From: Contact Centre (CRM) <contact@ribblevalley.gov.uk>
Sent: 29 September 2022 08:32
To: Planning
Subject: Planning Application Comments - 3/2022/0837 FS-Case-455099841

Planning Application Reference No.: 3/2022/0837

Address of Development: Inglemead, Waddington Road, Clitheroe BB7 2HN

Drawing No. A201 Revision

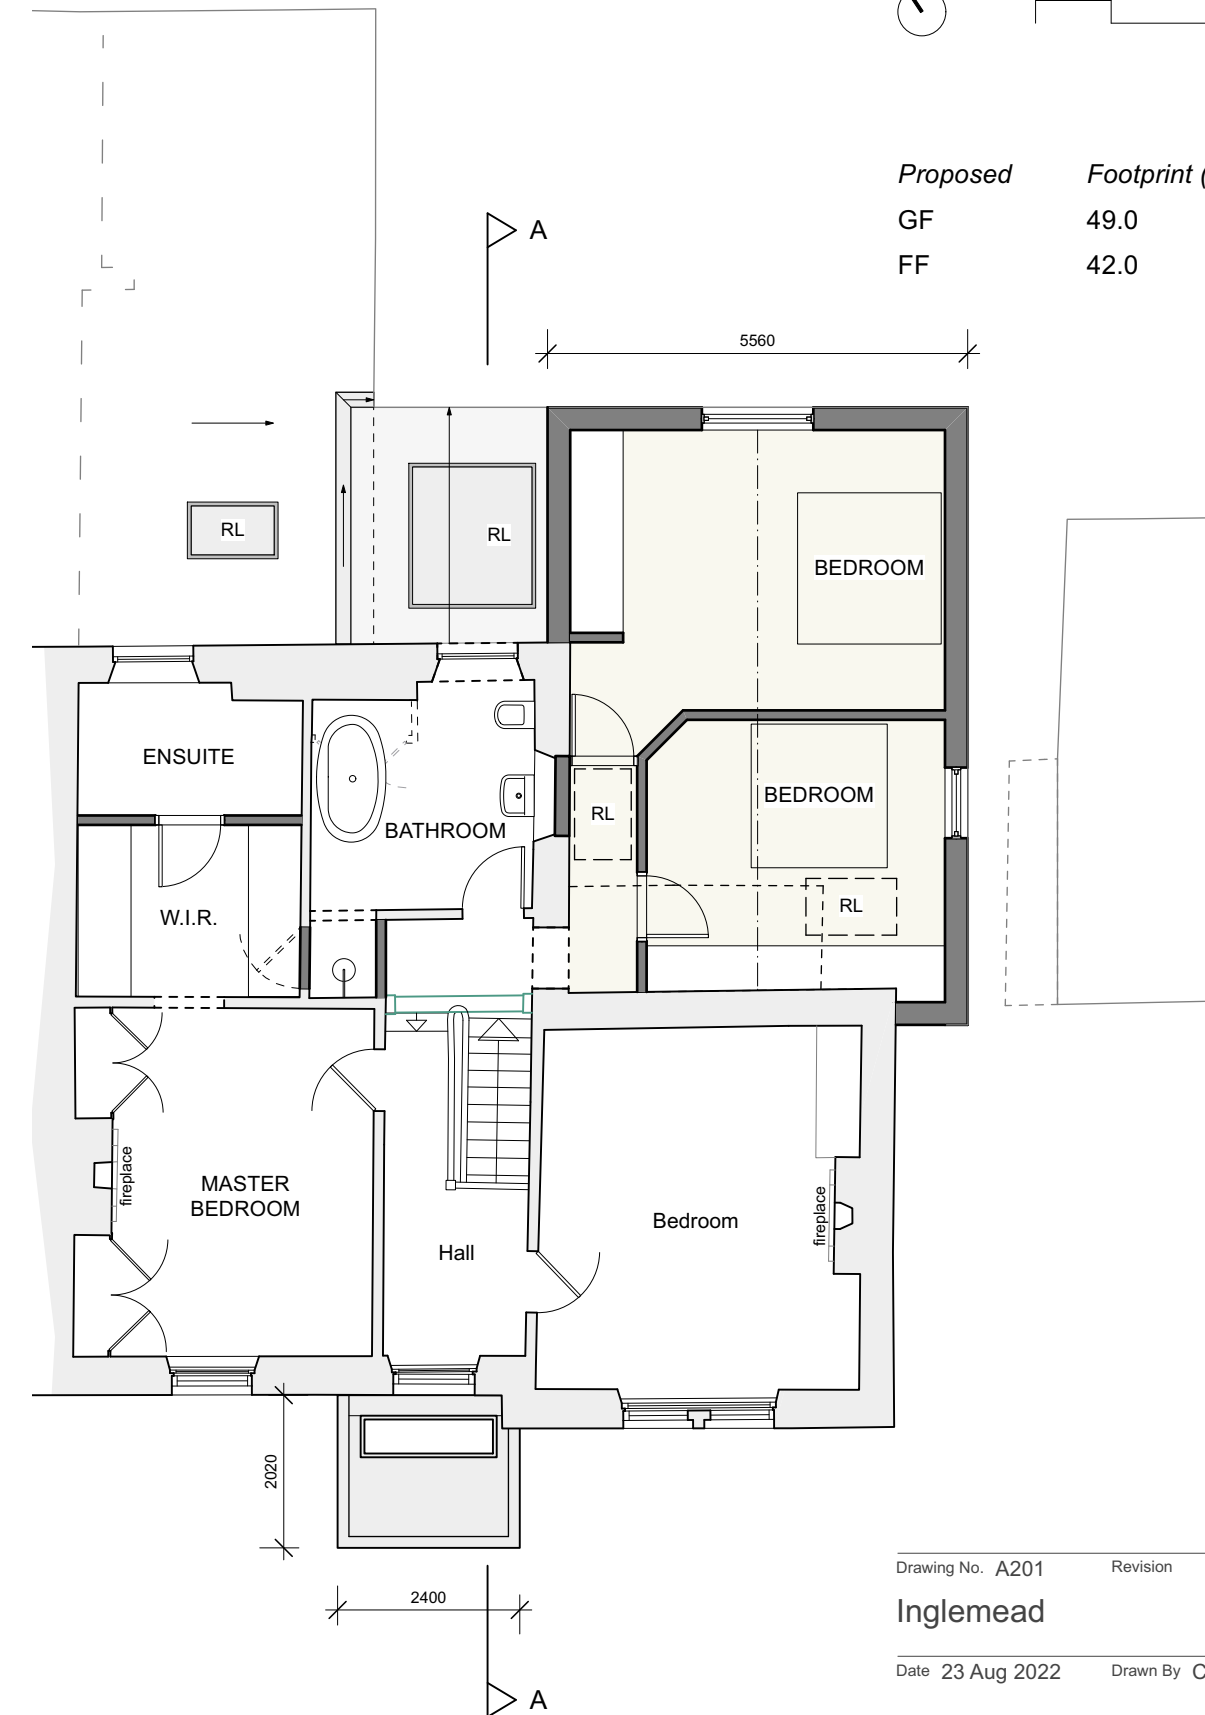
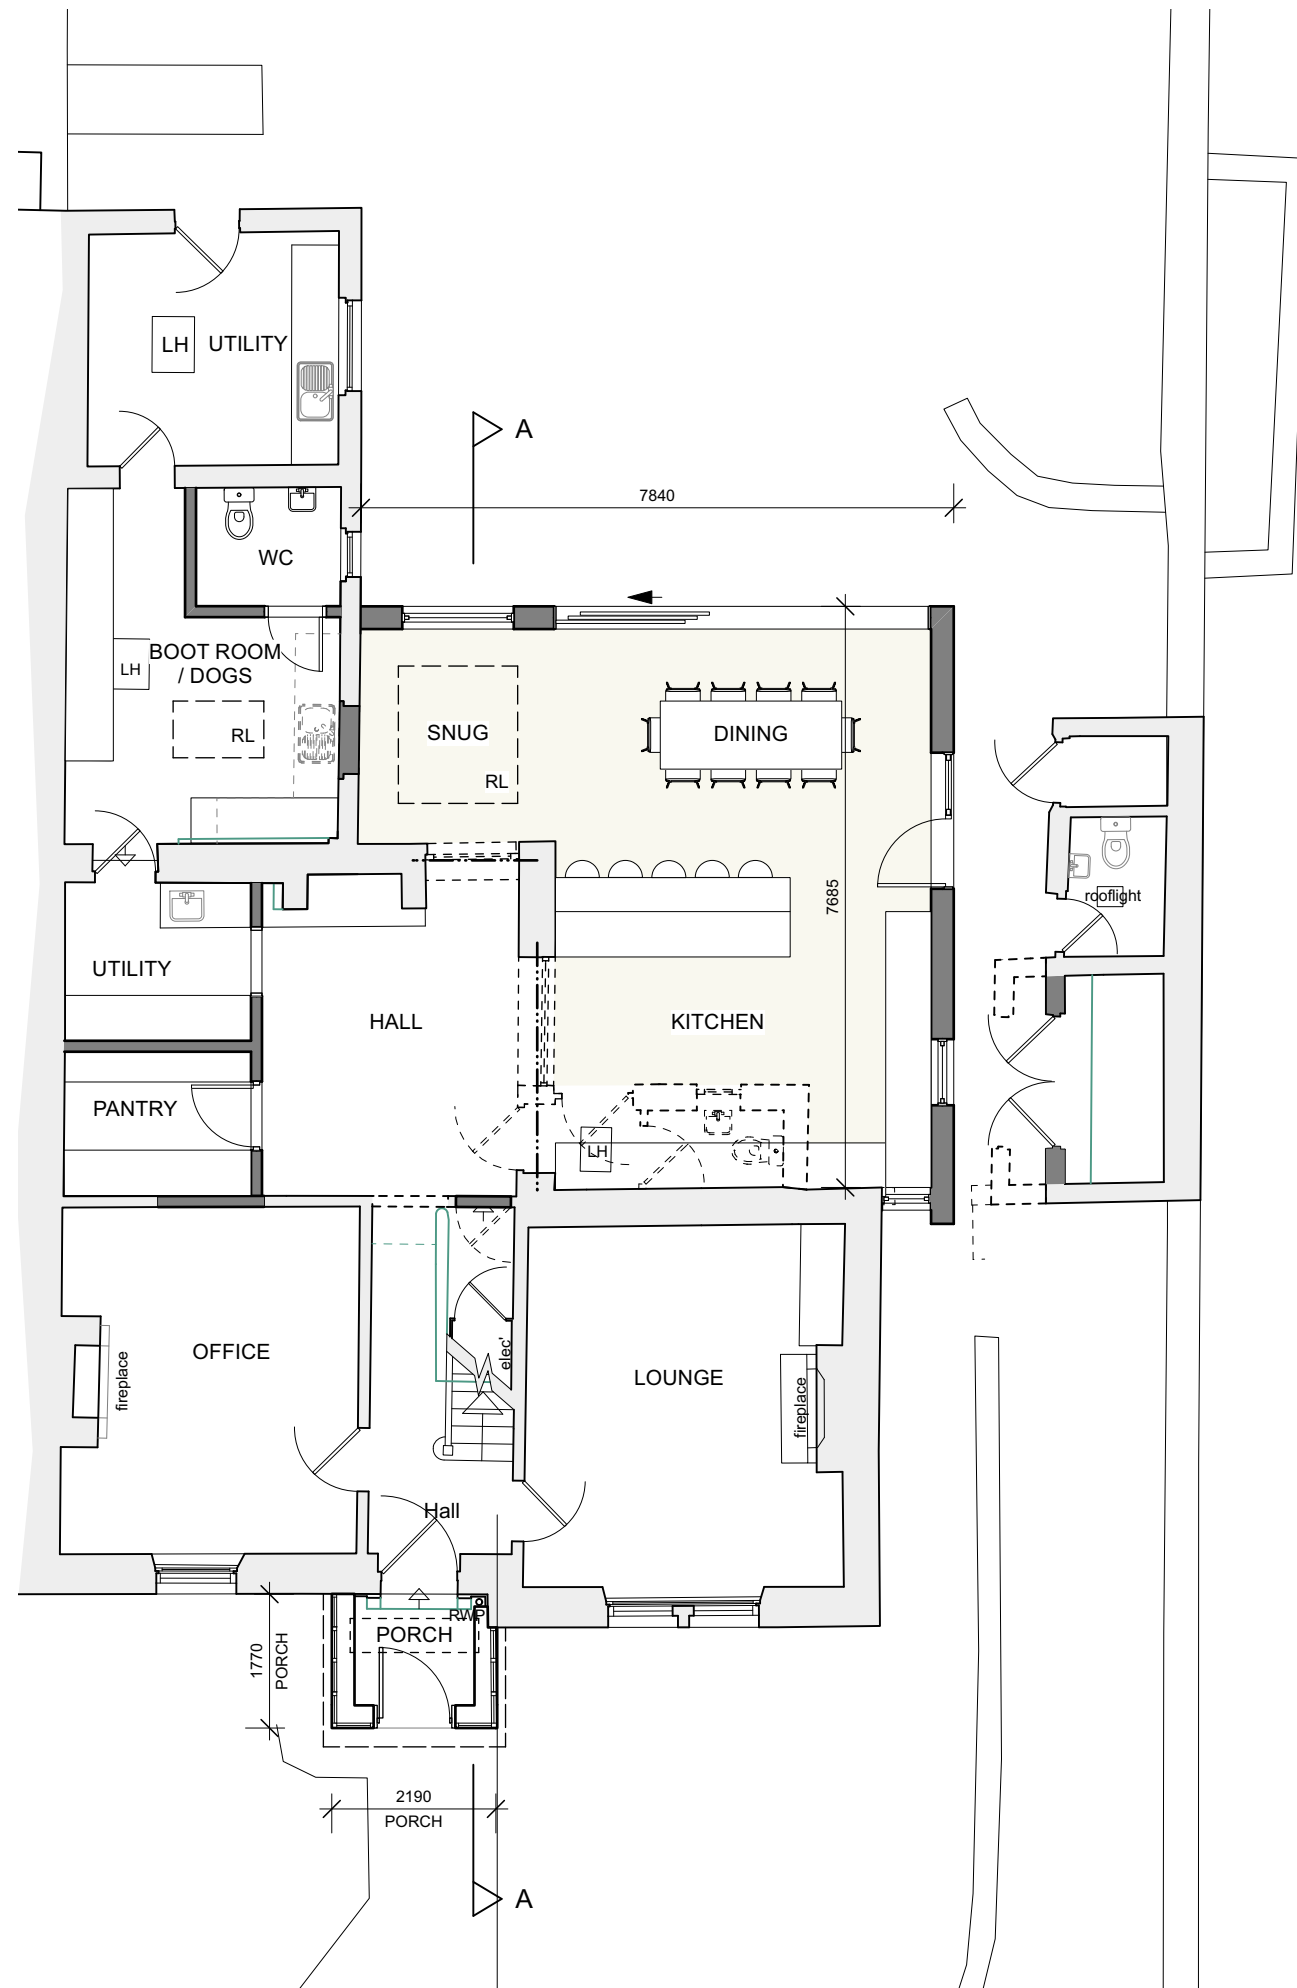
[REDACTED] are also concerned about the proposed replacement of the front porch as it is unclear as to the materials to be used for this .

1 PROPOSED SOUTH EAST ELEVATION
Scale: 1:100

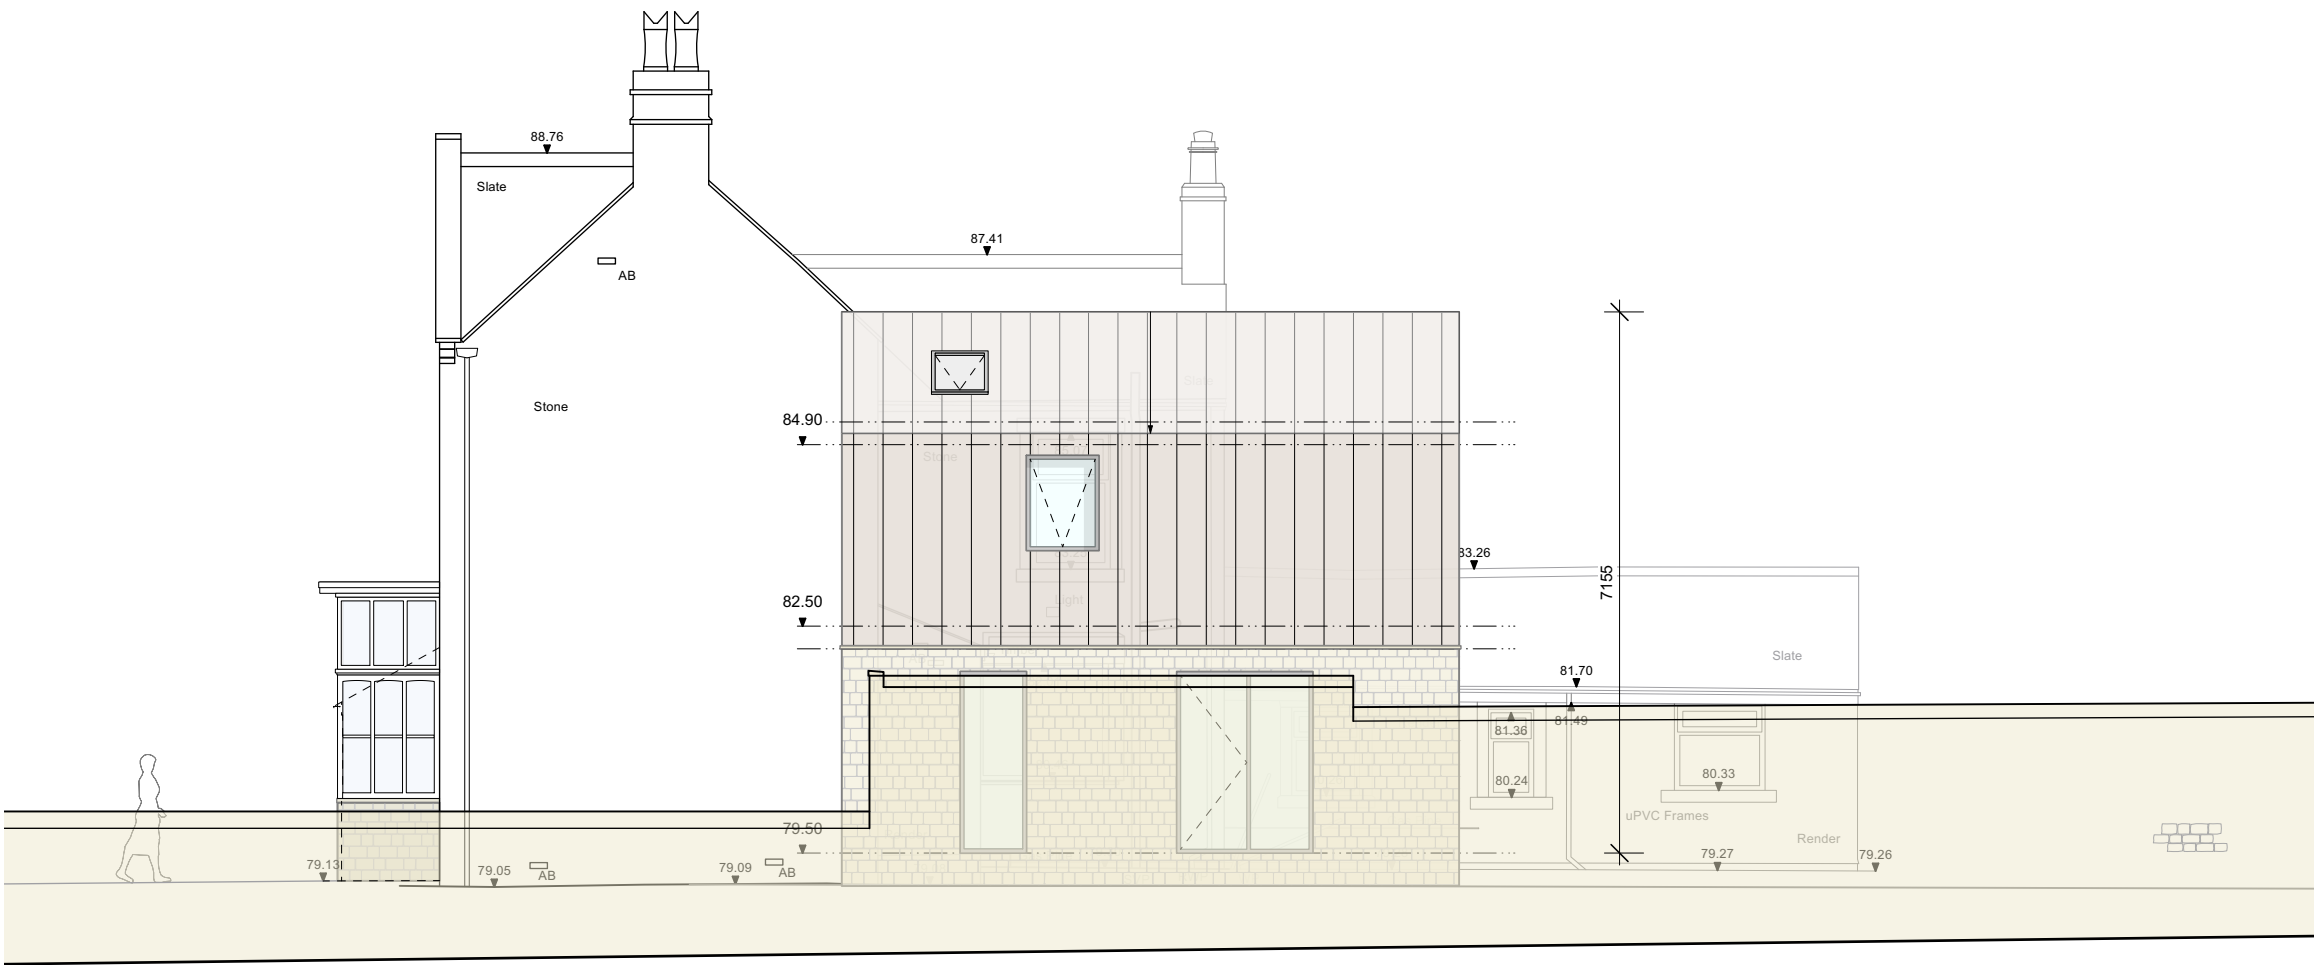
1) Loss of privacy [REDACTED] The 1st floor extension window allow the residents at Inglemead on Waddington Road [REDACTED] Could not locate a mention of privacy/frosted glass.

2) The exterior finish of the extension, it is not in keeping with the nearby houses of Waddington road and on Hawthorne Place - it's an old part of town, which is it's unique selling point.

Whilst [REDACTED] do not have any objections to the actual extension as it , and the proposed renovations to the inside of the house would be of great benefit to the owners [REDACTED] are VERY much concerned about the proposed materials to be used , especially on the 1st floor and roof .

The proposed use of " Standing seam sheet metal in bronze " (Design & Access Statement 2.1) is not in keeping at all with these houses and will be CLEARLY seen from both Hawthorne Place and Waddington Road (Design and Access Statement 2.4) and certainly not attractive .
